Re: Letter of Intent . . . EA-17-075 ARACO ENTERPRISES, LLC
Drive (APN 65244-00-085)

Letter of Intent_V3.pdf Markup Summary

SITE DEVELOPMENT PLAN
EL PASO COUNTY, COLORADO

FILE NO. EA-17-075

SITE DEVELOPMENT PLAN
EL PASO COUNTY, COLORADO

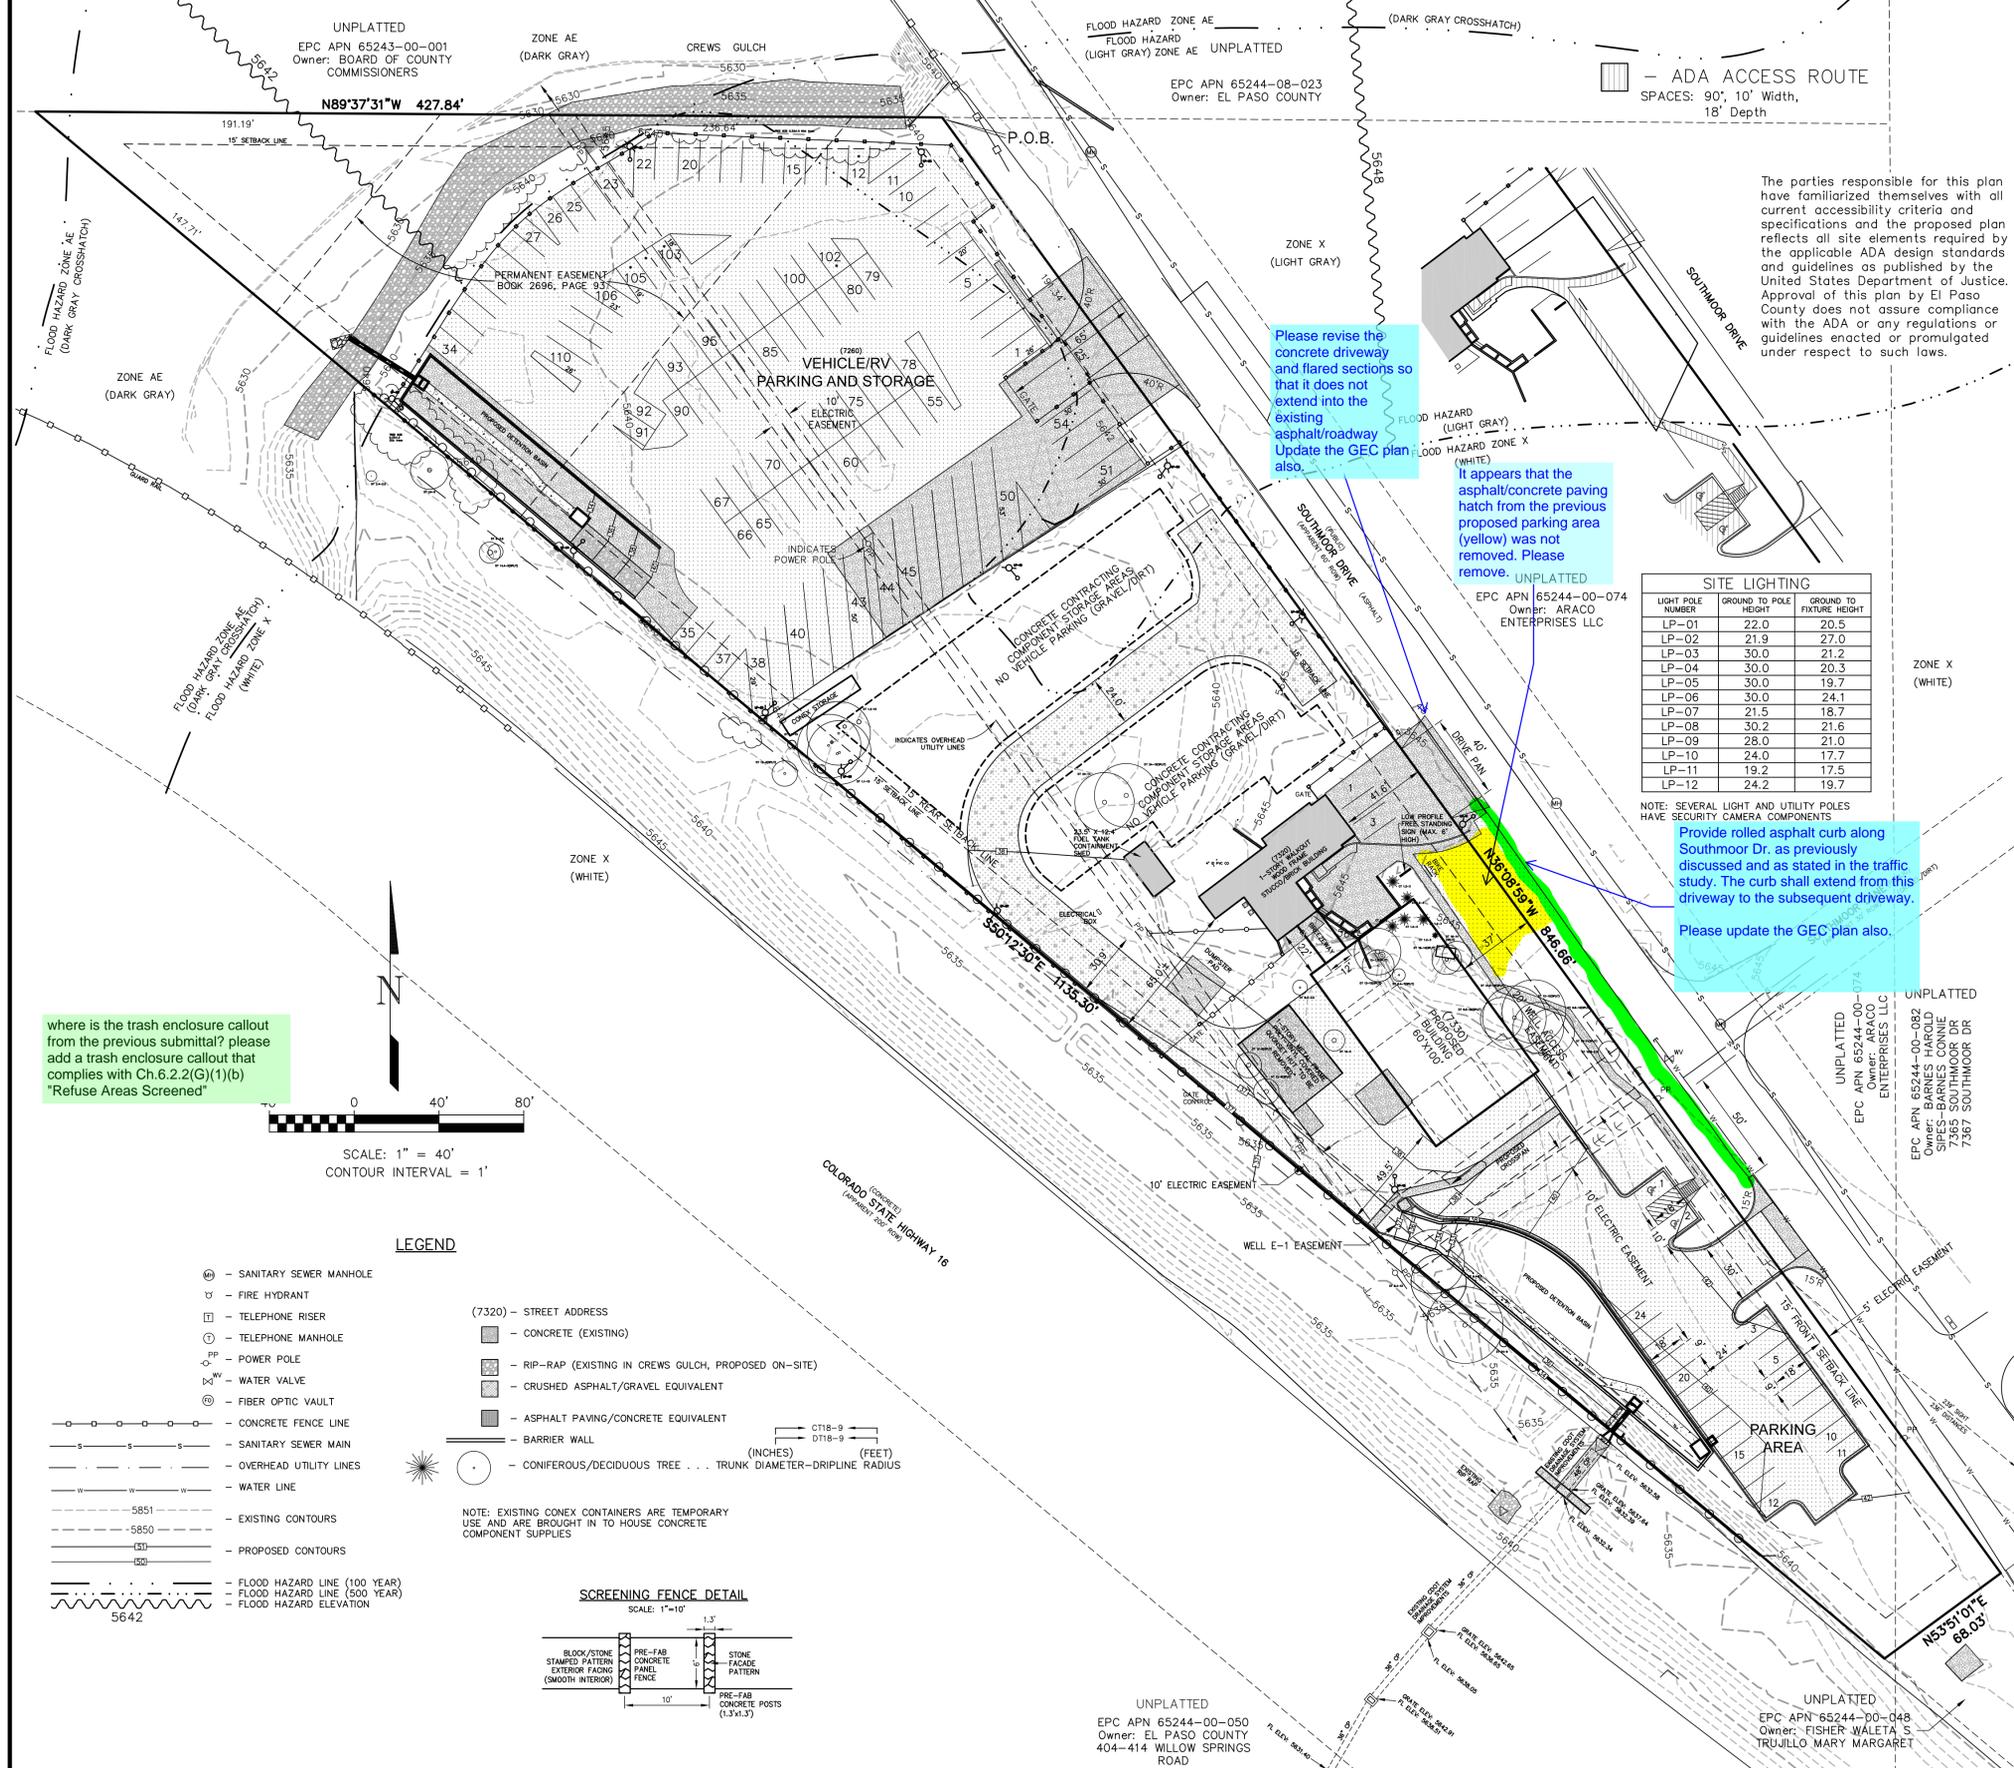
The dumpster enclosure appears to be enclosed / screened on only 3 sides and is also unclear as to the direction and whether there is a gate to the enclosure or if the front is open, etc. (though it is difficult to verify all this via the detail).

Please either clarify in your dumpster enclosure callouts, or revise the proposed dumpster enclosure, to comply with Ch.6.2.2(G)(1)(b) "Refuse Areas Screened"

the engineering manager is amenable to a 3rd access point although the driveway shall be limited to 40' wide per criteria. Currently the driveway shown is +11'. Provide the appropriate curb/gutter at this location such that the driveway is limited to max 40' wide. Additionally, a sign indicating that there shall be no backing into Southmoor drive shall be provided. Staff has discussed this information with your traffic engineer.

DUMPSTER PAD TO BE
MOVED BEHIND CONCRETE
PRE-FAB PERIMETER
FENCE TO DETER
UNAUTHORIZED USE OF
TRASH DUMPSTERS - DVH

CREATED 40' WIDE
DRIVE PAV FOR
DUMPER/EMPLOYEE USE
OF TRAFFIC (3) PARKING
SPACES w/ SIGNAGE
INDICATING "NO BACKING
INTO SOUTHOOR DRIVE" - DVH
